Description: To provide production facilities for the manufacture of pizzas, together with associated amenities and facilities

Location: Sluice Road
Holbeach St Marks

Amendment: Reduce size and amend design of reception area at western end of pizza building

**TOWN AND COUNTRY PLANNING ACT 1990
NOTICE OF ACCEPTANCE OF AMENDMENT**

1
553 PROPOSED BUILDING SECTION SCALE 1:50

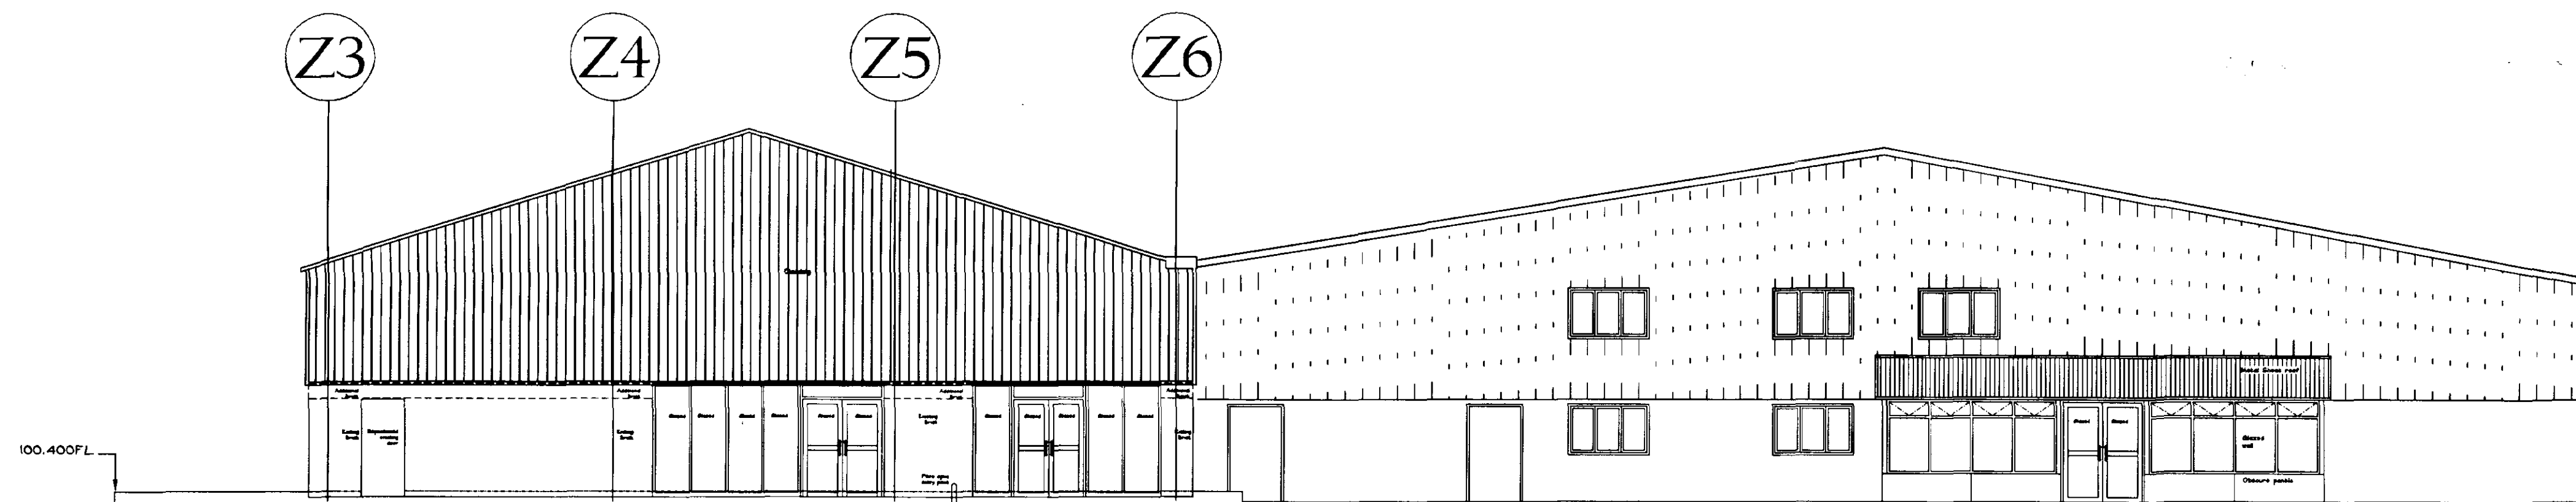
Amendment: Amend canteen & amenity reception area (dwg nos. 03-27/499, /500, /501B, /550, /551, /552 & /553)

Further to your recent discussion with Jo Willis I enclose details showing our proposals for the Canteen and Amenity Reception area in existing buildings at Geest, Holbeach.

(03 - 27)	499	Site Plan
	500	Existing Amenity Ground Floor Plan
	501B	Proposed Amenity Ground Floor Plan
	550	Existing Plan For Workshop, Canteen and Shop
	551	Proposed Plan For Workshop, Canteen and Shop
	552	Existing Section and Elevations For Workshop, Canteen and Shop
	553	Proposed Section and Elevations For Workshop, Canteen and Shop

The amended details submitted in respect of the above proposal have now been considered and there are no objections to the amendment being implemented to the extent described above.

DRAWING
**PROPOSED ELEVATIONS
OF NEW
CONSTRUCTION**

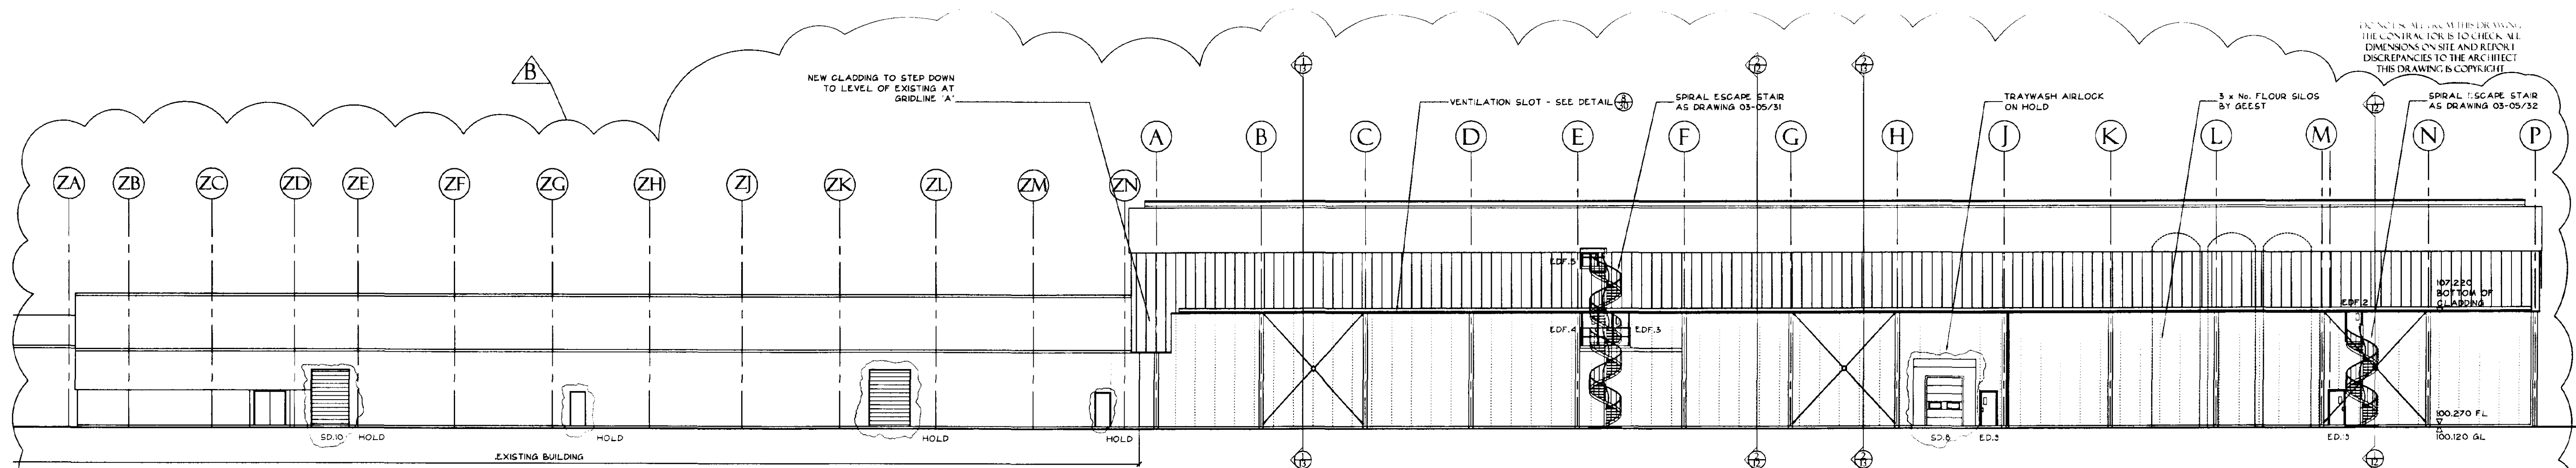
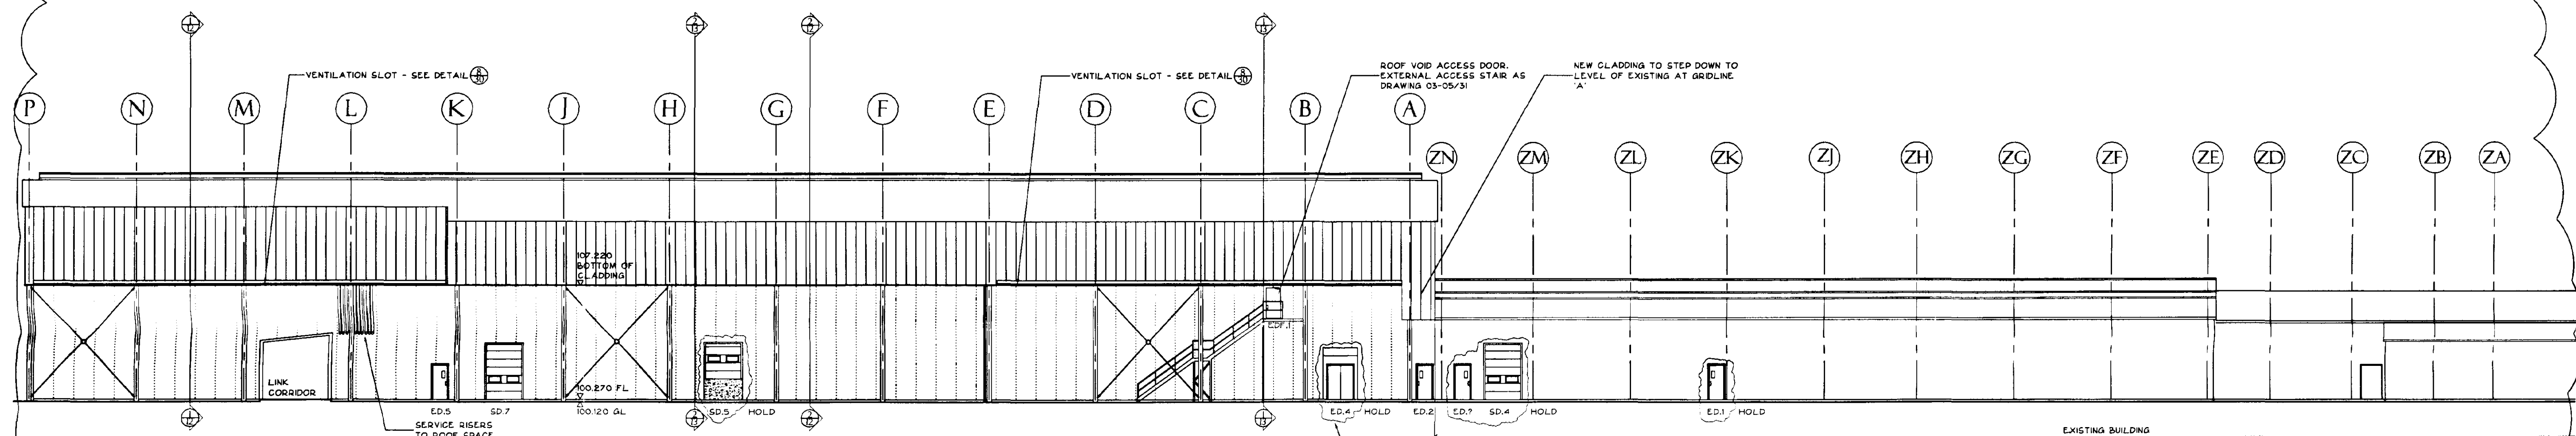
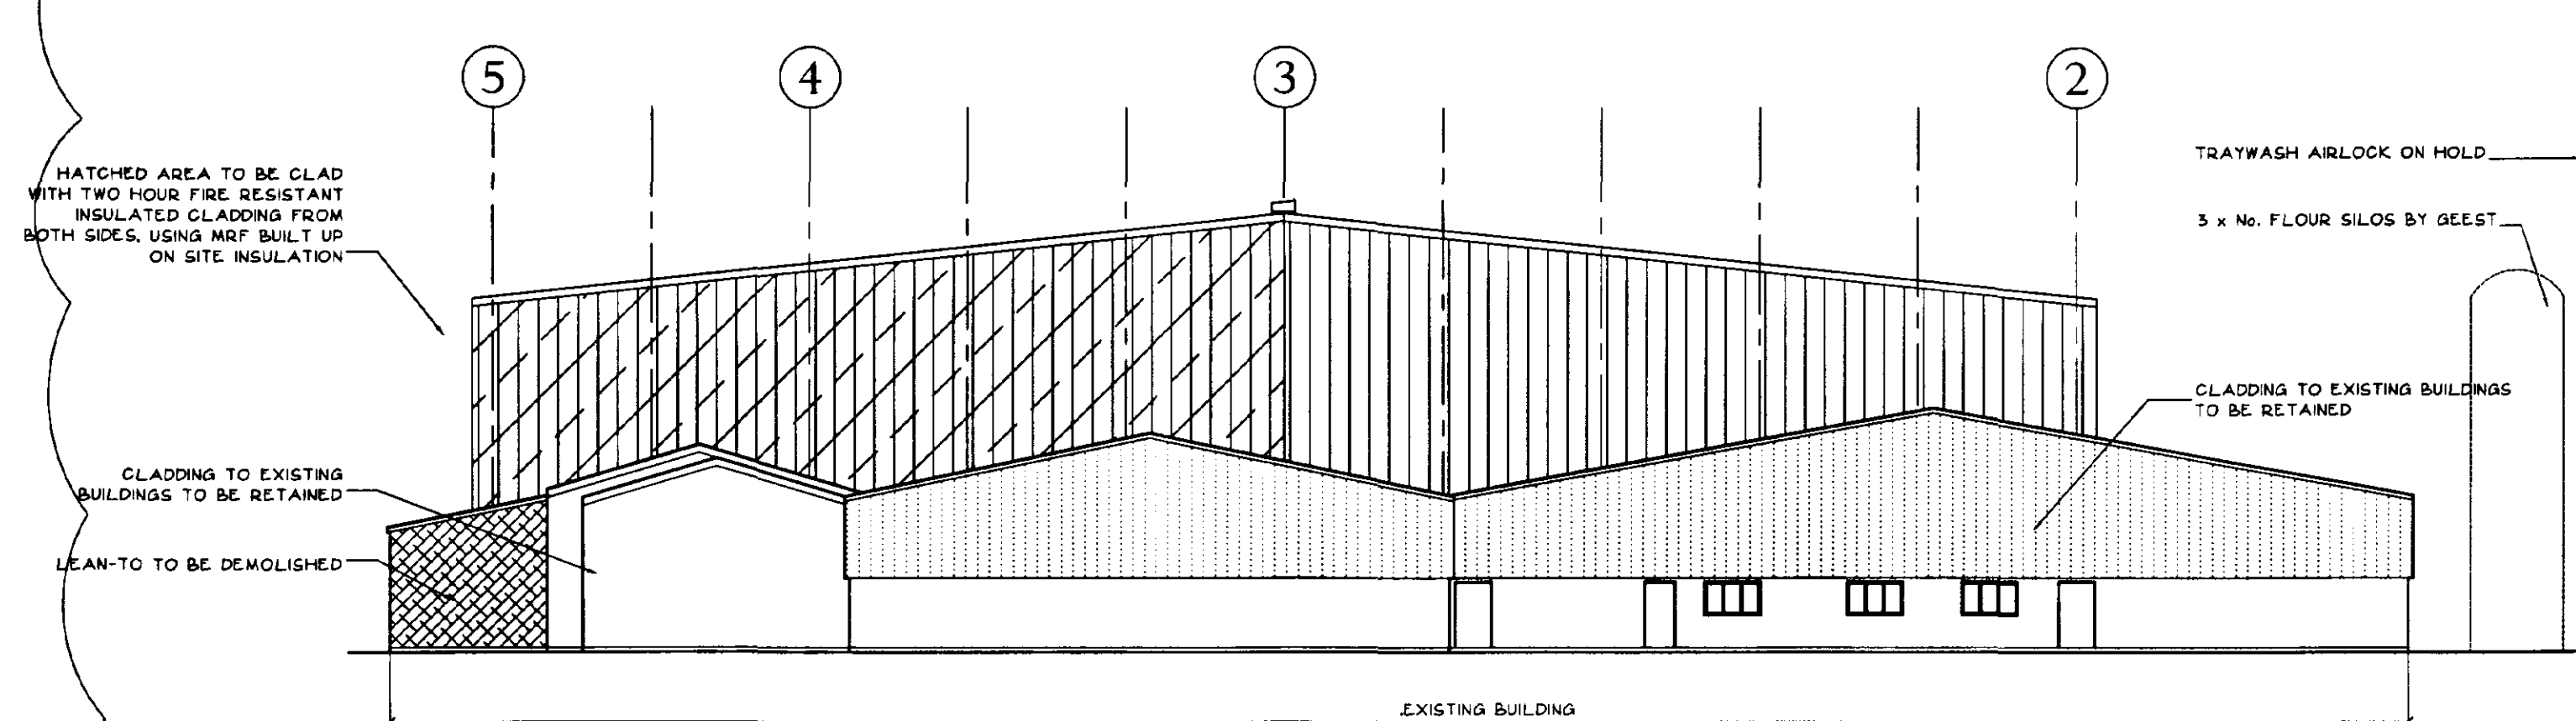
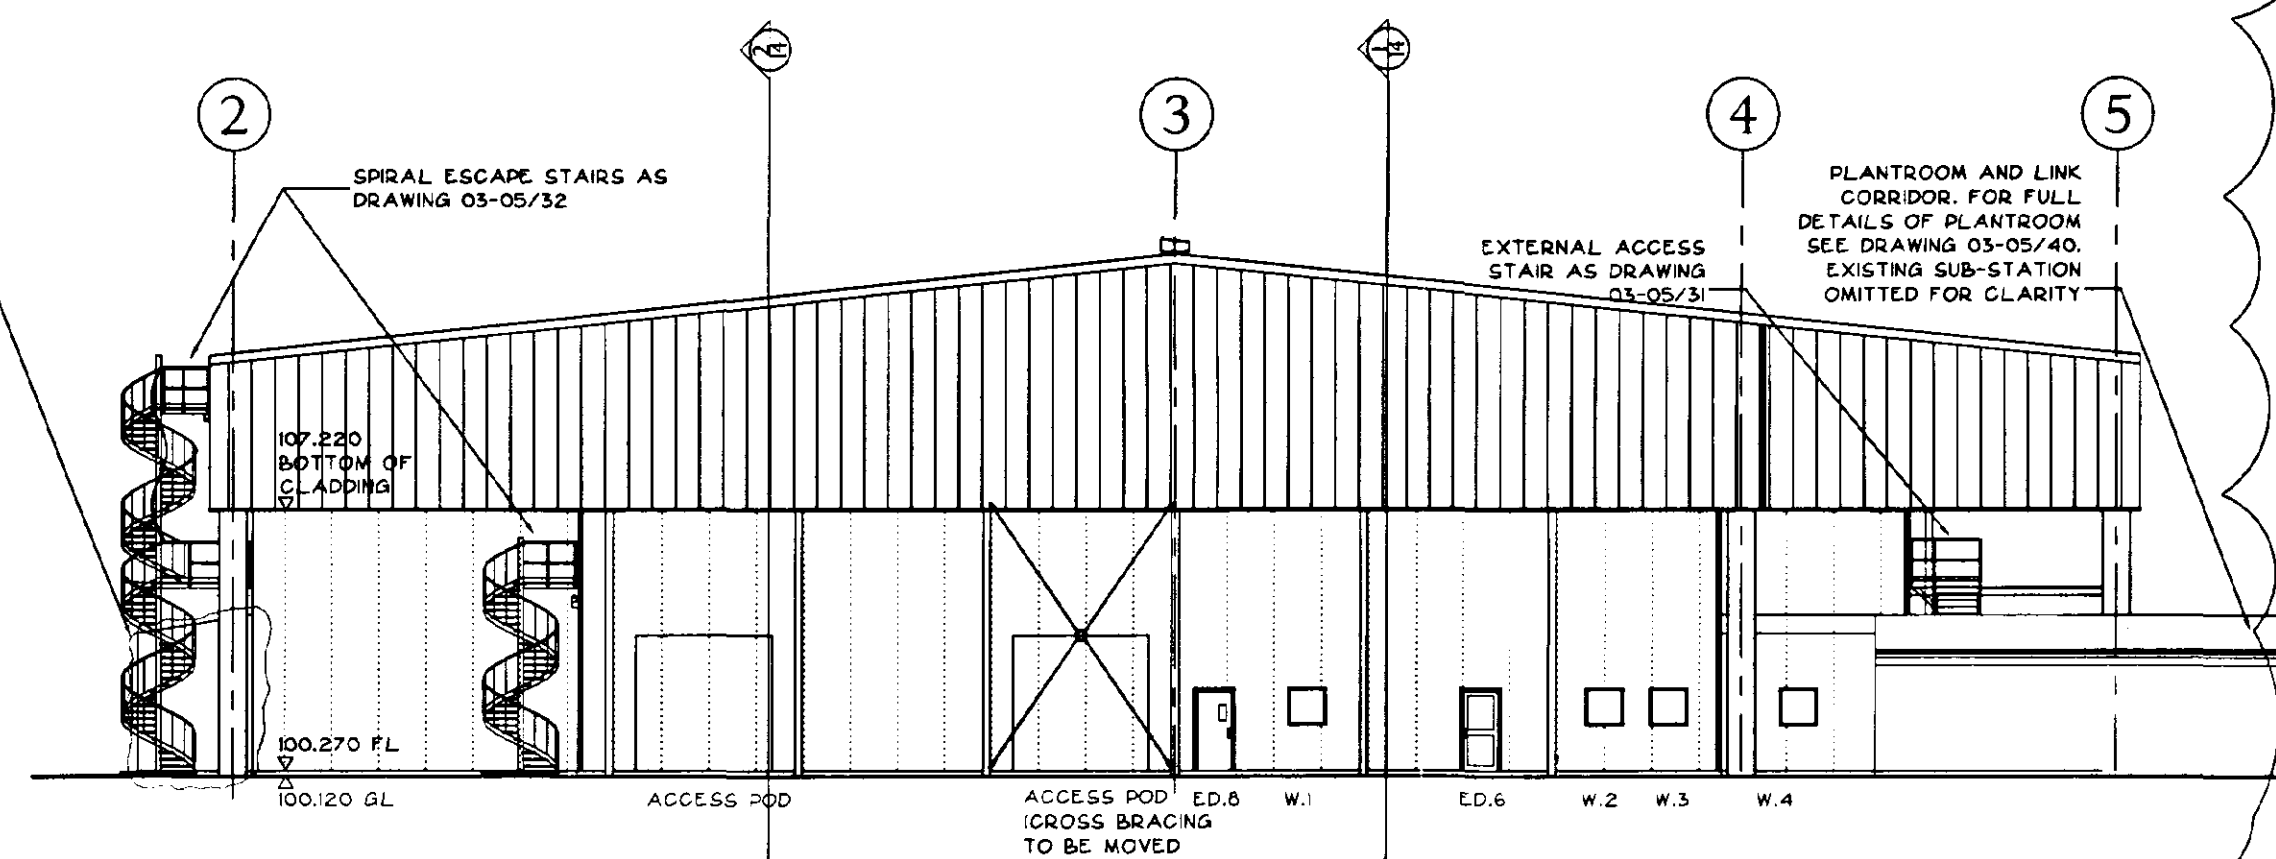
Amendment: Amended building design/layout including reduced height
Dwgs.03-05/02J;/03H;/04C;/05B;/10B;/12F;/13D & /14C

The major change from the original application drawings is the reduction in the main building height of about a metre.

The amended details submitted in respect of the above proposal have now been considered and there are no objections to the amendment being implemented to the extent described above.
